From: Brian Banister [REDACTED]
Sent: 05 May 2022 09:49
To: Planning.Responses <Planning.Responses@arun.gov.uk>
Subject: Re: Planning Consultation on: WA/41/22/HH

Application No: WA/41/22/HH

Site Address: Aylings Cottage West Walberton Lane Walberton BN18 0QF

Description of Works: Removal of existing rear projection and erection of single storey rear extension. This application affects the character and appearance of the Walberton Green Conservation Area.

PROPOSED SINGLE STOREY EXTENSION AT 'AYLINGS COTTAGE', WEST WALBERTON LANE,
WALBERTON FOR MR. & MRS. S. DACE.

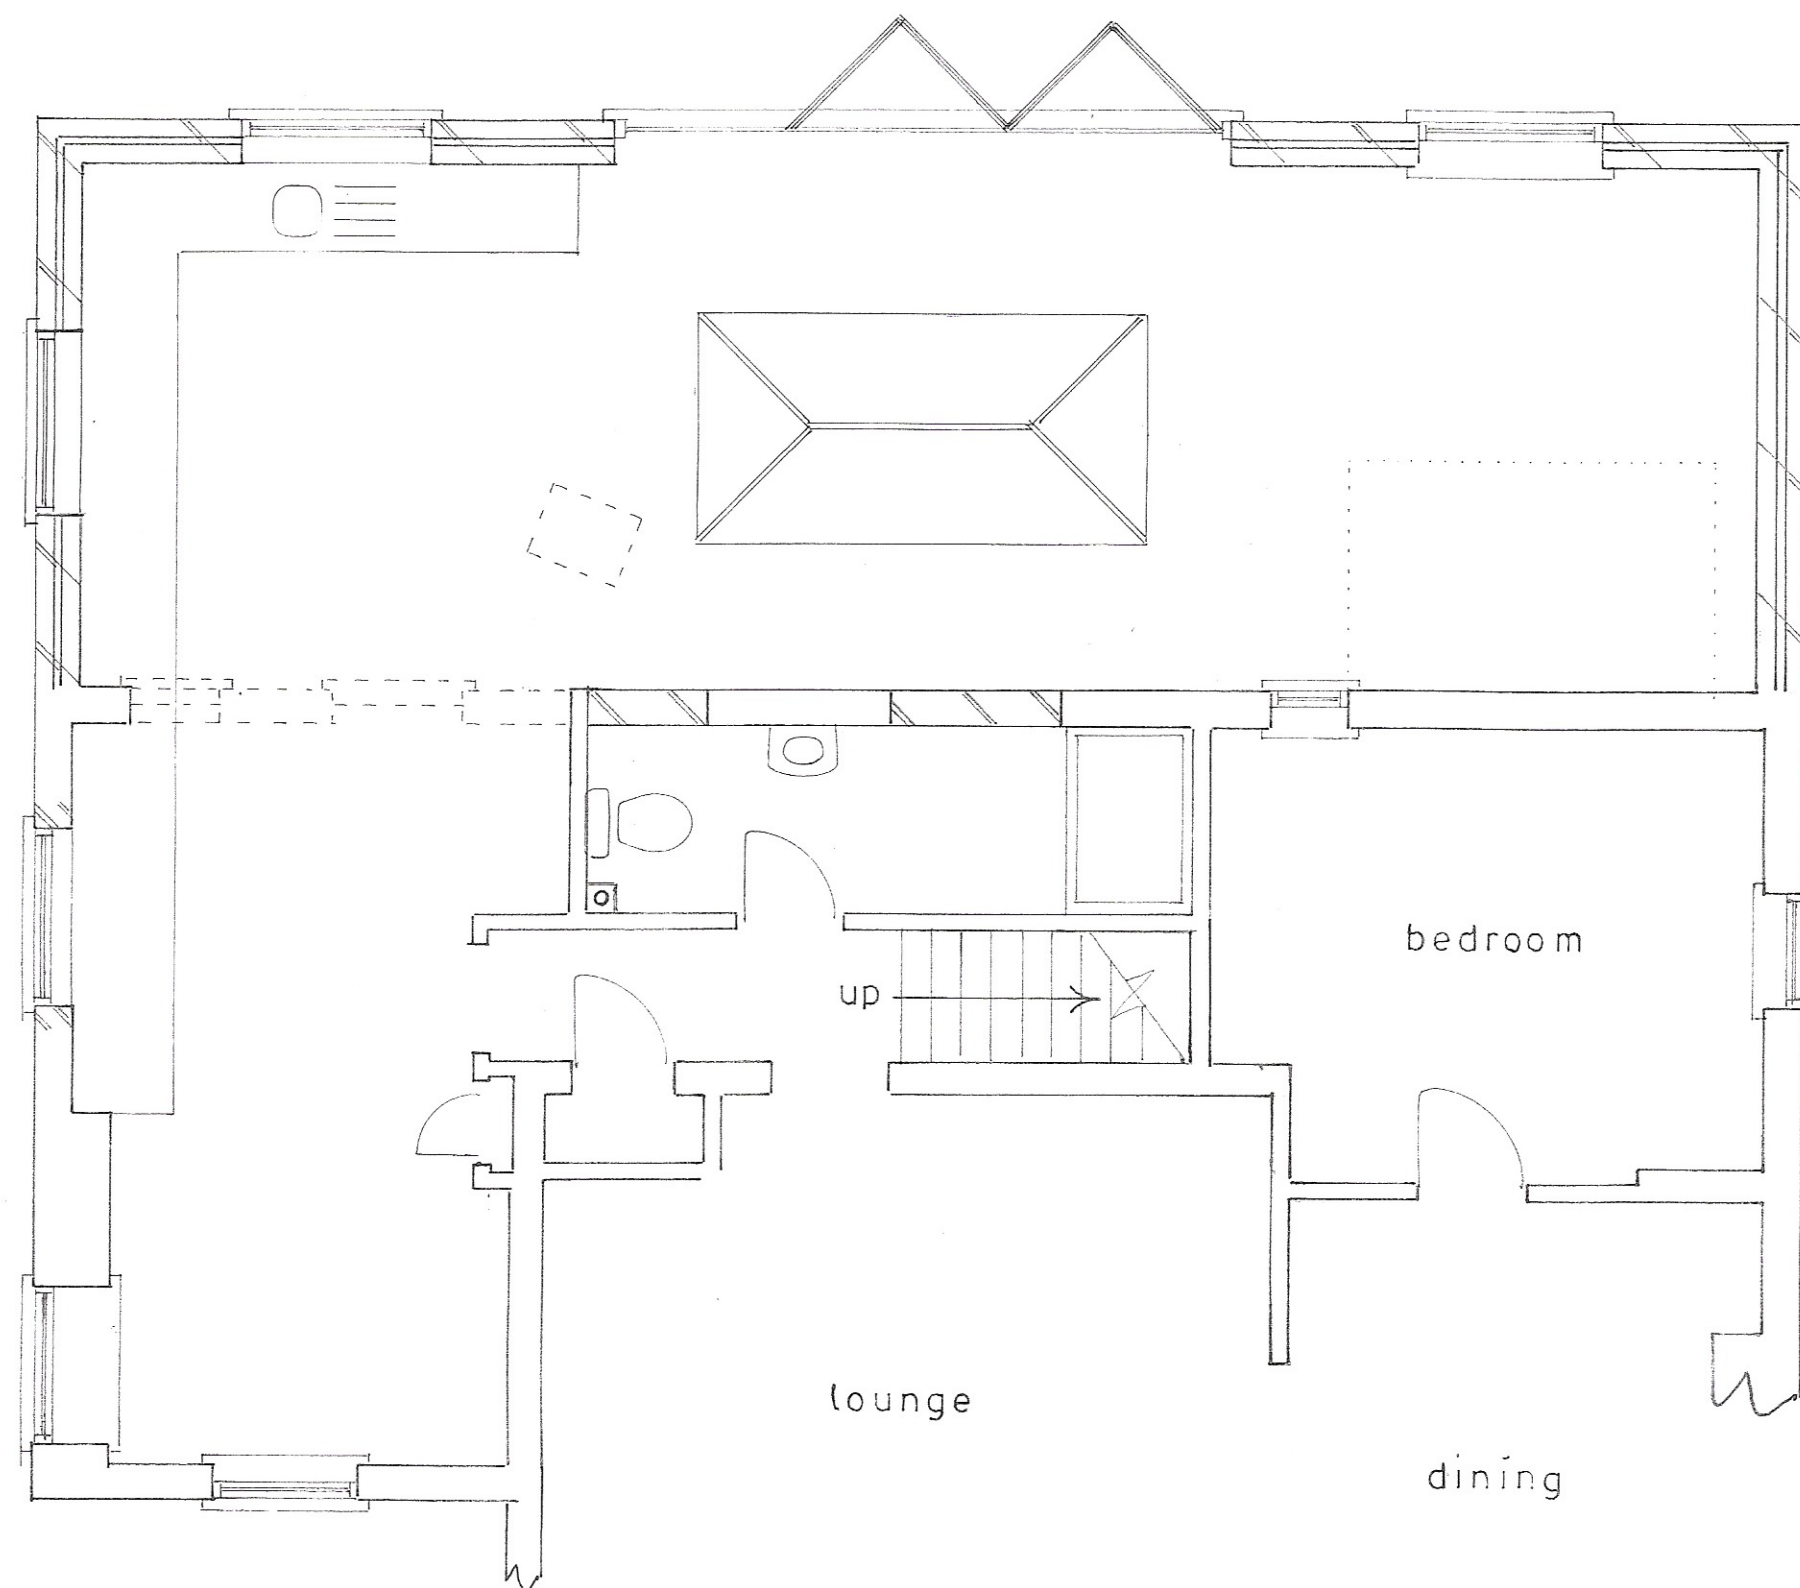
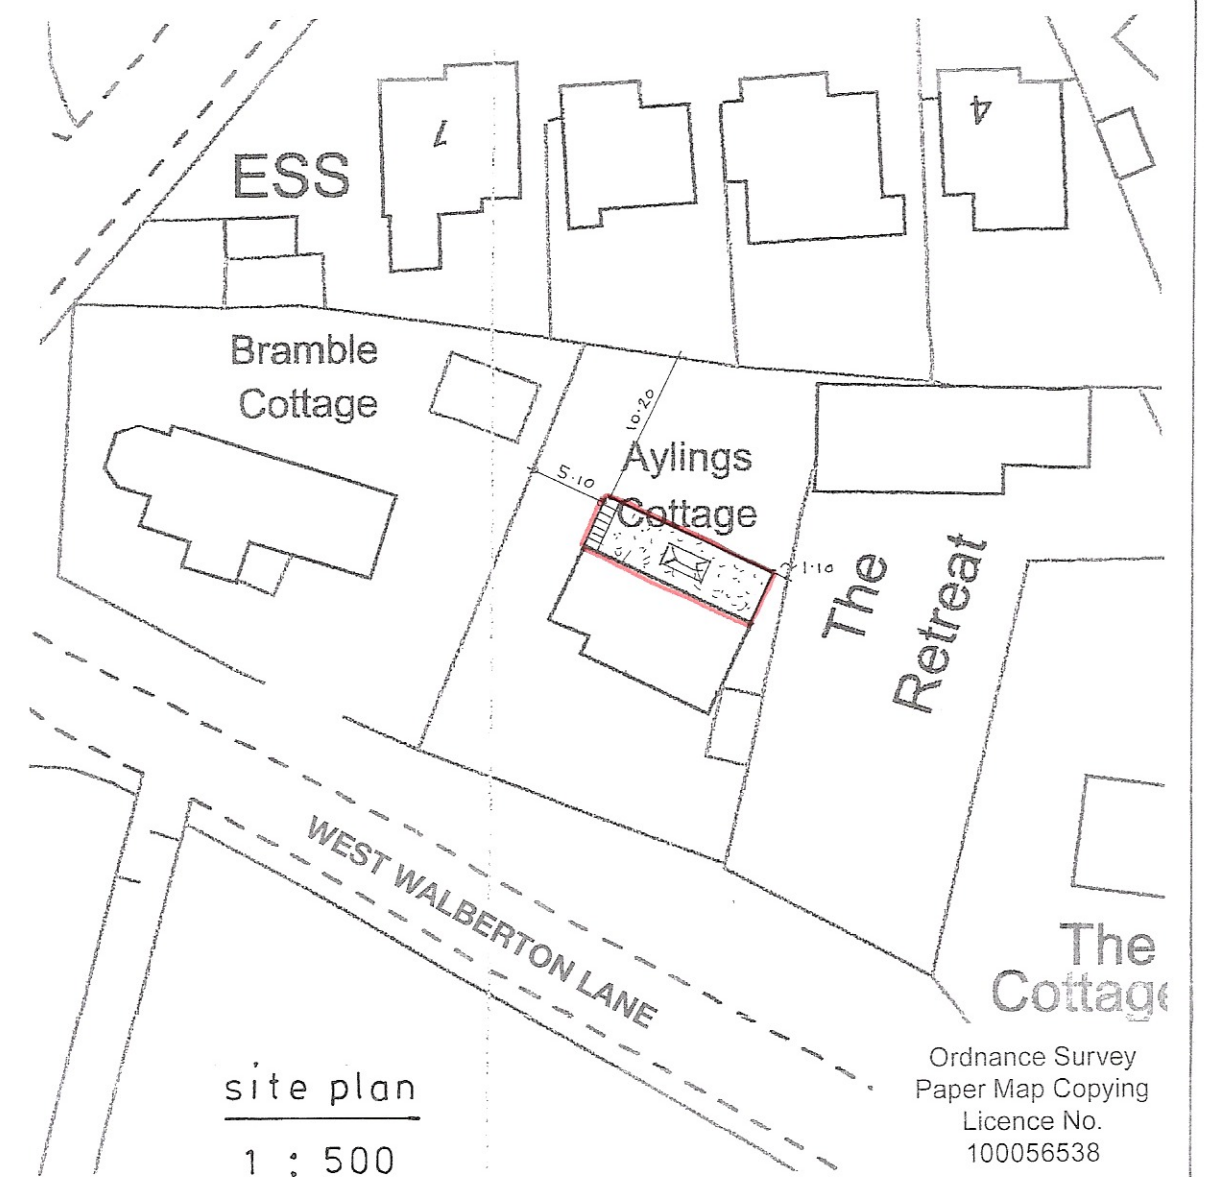
Although currently screened from the road frontage, the setback of the adjoining building to the east means that there is the possibility of the proposed flat roofed extension being seen from the roadway in the future. As such the Panel would prefer to see the eastern side wall of the proposed extension recessed from the eastern side wall of the host building rather than in the same plane. This would leave the rather attractive catslide roofed flank elevation of the main building as the dominant, uncompromised, feature.

Aylings Cottage appears to date to the late 18th/early 19th century and with its attractive appearance and form it makes a positive contribution to the character and appearance of the conservation area. It could possibly be considered as a non-designated heritage asset. Perhaps it would be better if both side walls of the proposed extension were inset from the side walls of the host building in order to ensure that the extension is visually subservient.
